72 MUNJAY.

9/9/15 FINAL PLAN COMMENTS (Updated from Preliminary Plan comments , 8/24/15. Highlighted comments remain to be addressed, red represents additional comments.)

Zoning

SITE PLAN

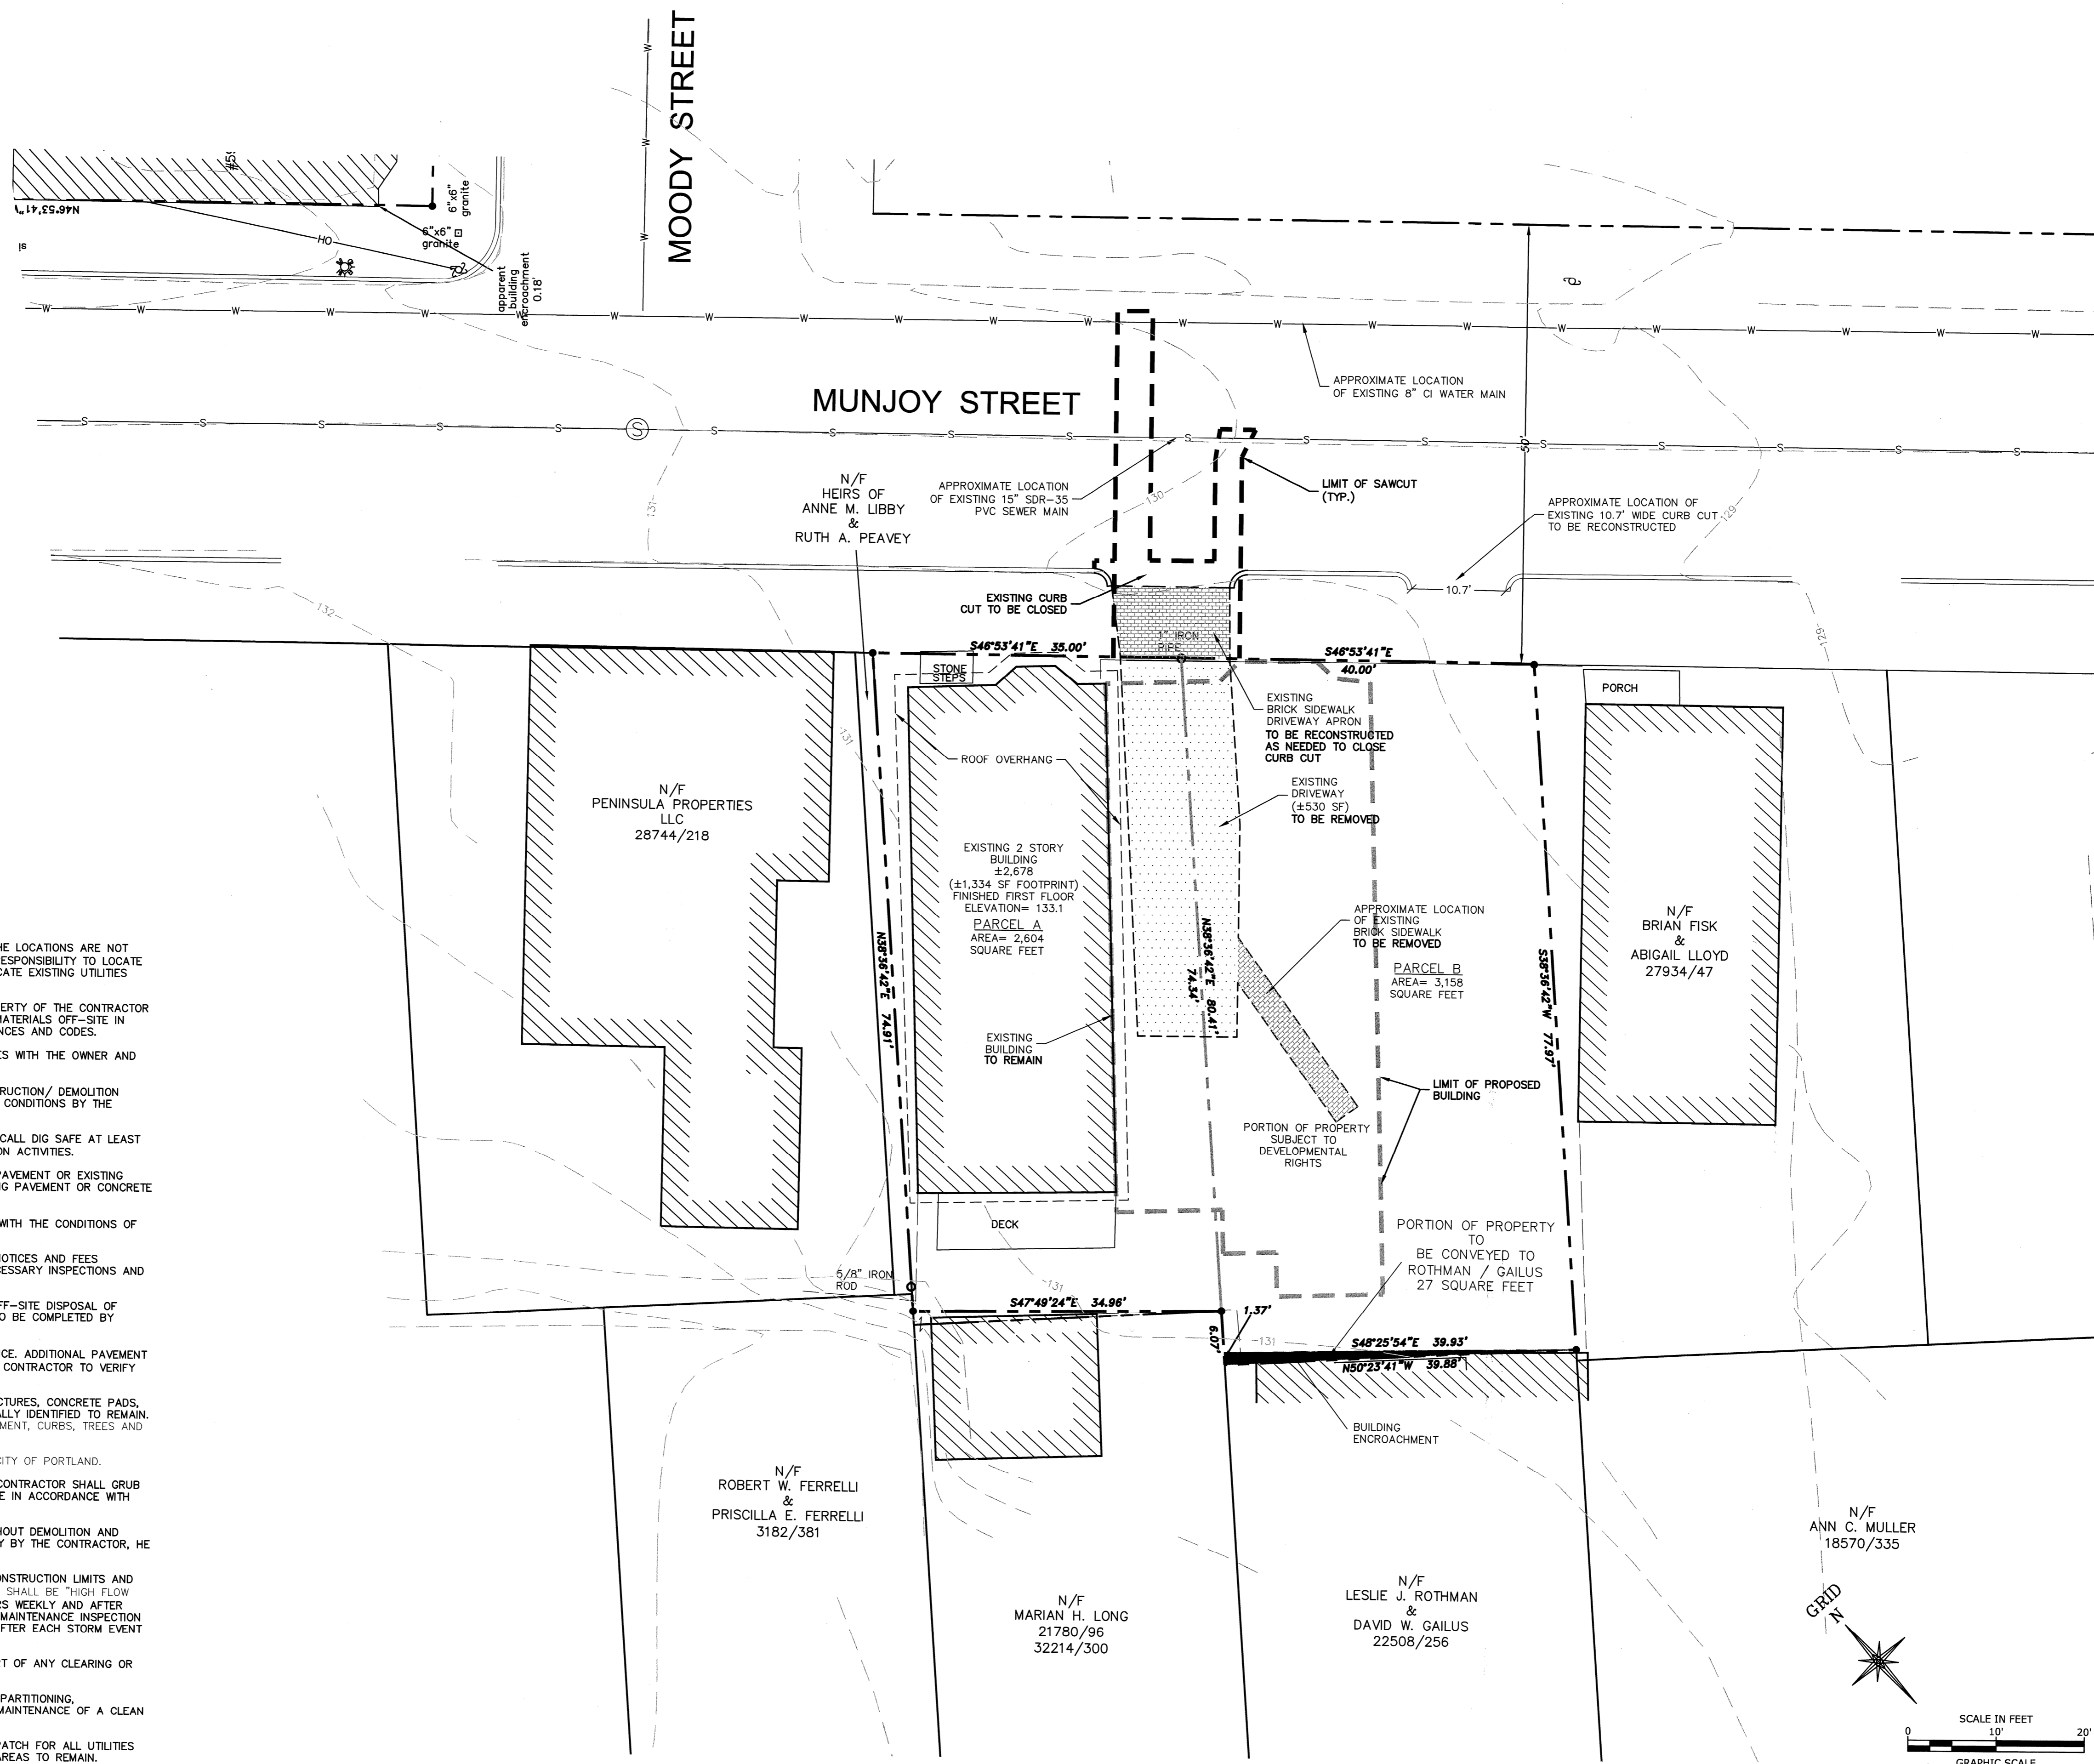
-The site plan should show distance from the front property line. Note that, per your submittal, the average between the two adjacent setbacks is .25' (0' to the north and .5' to the porch at south). This means that the building should be setback .25' or 3 inches.

- On the revised plans, please show:
Steps and door locations-

A rack accommodating two bikes. This rack should be proximate to the door. Note that in previous instances, we've required bike racks to be installed outdoors. I am discussing this case with other reviewers and will let you know whether any changes are needed.

Parking space dimensions
Snow storage-

-The autoturn graphic you provided shows parking maneuvers encroaching onto the adjacent property. Please revise such that cars will not need to occupy the adjacent lot.

-Please verify the distance from the curb cut which will be retained to the property line and to the neighboring building to the south. The location of this curb cut in the plans does not seem to match the field.

PENINSULA PROPERTY DEV.
 robertleblanc1@me.com
 DRAWING **LEFT ELEVATION**

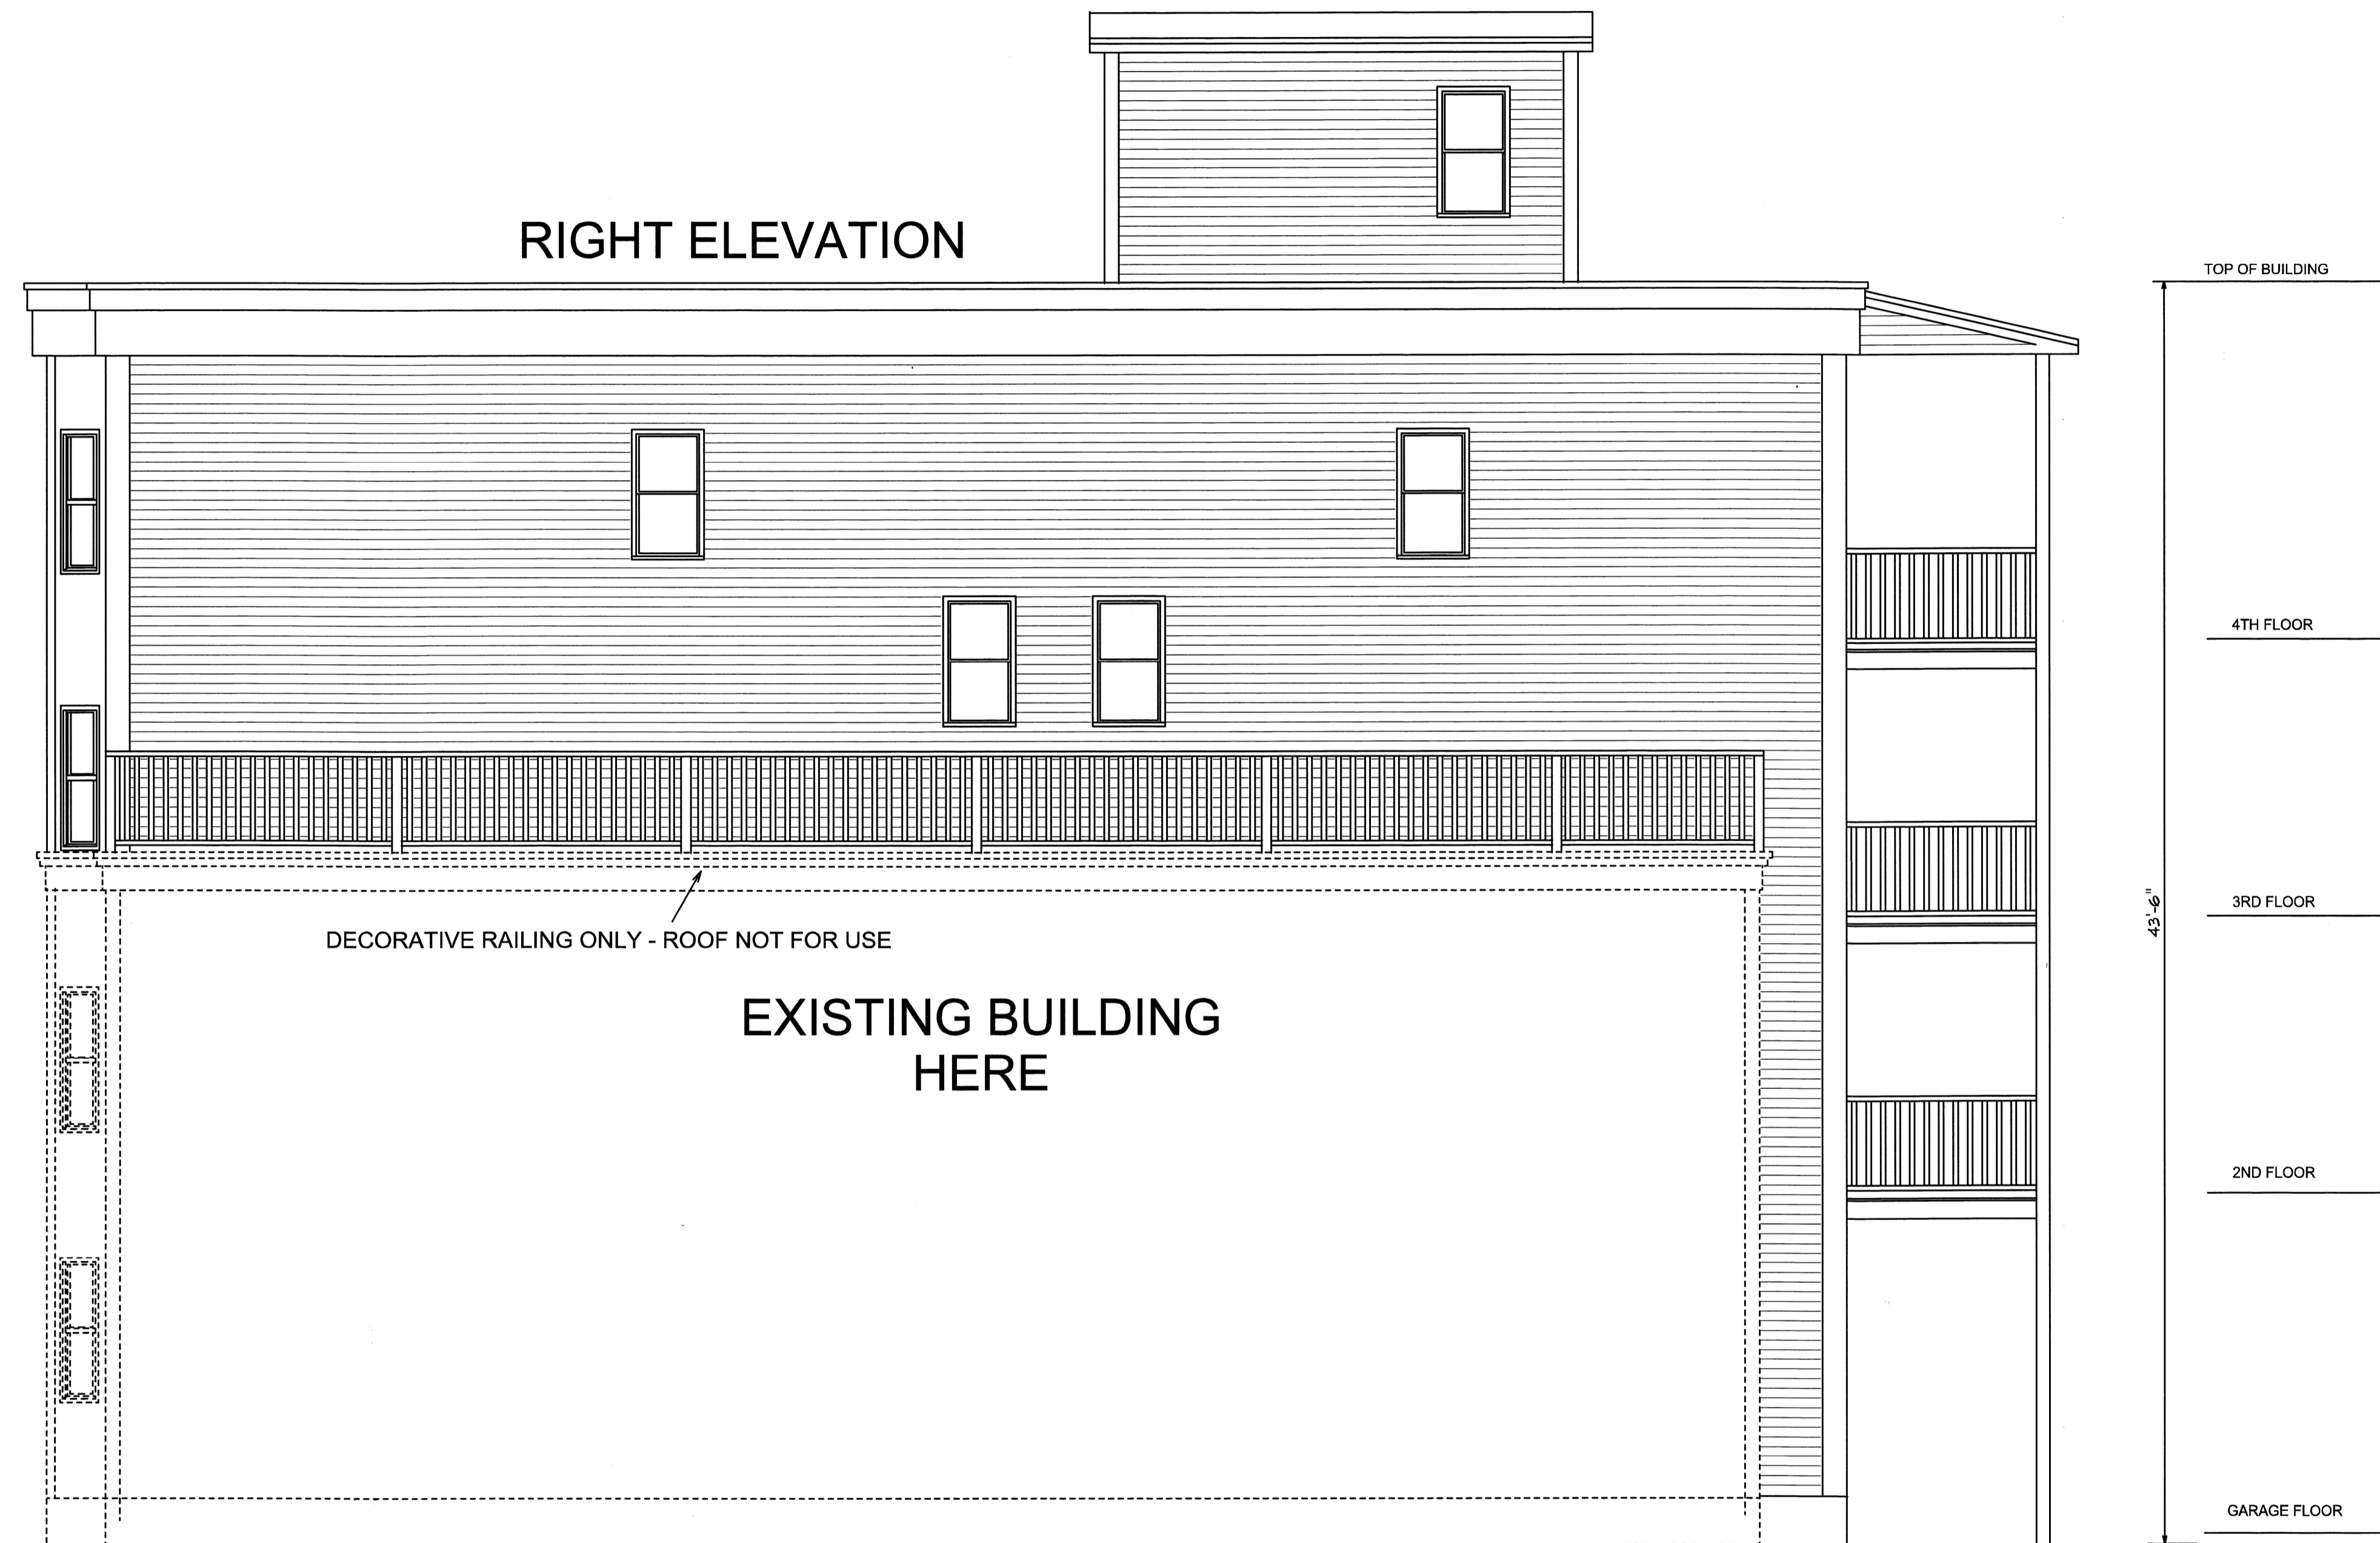
CM - fenestration pattern should emphasize history
here - these renderings - not making me want to support
need more articulation.

CM. D-1 - rectangular + vertical proportions

- Please provide additional renderings. A tree obscures much of the building in the street view that you provided. See comments from urban designer related to this request. At the very least, we need to have revised elevations showing the windows as recently proposed.
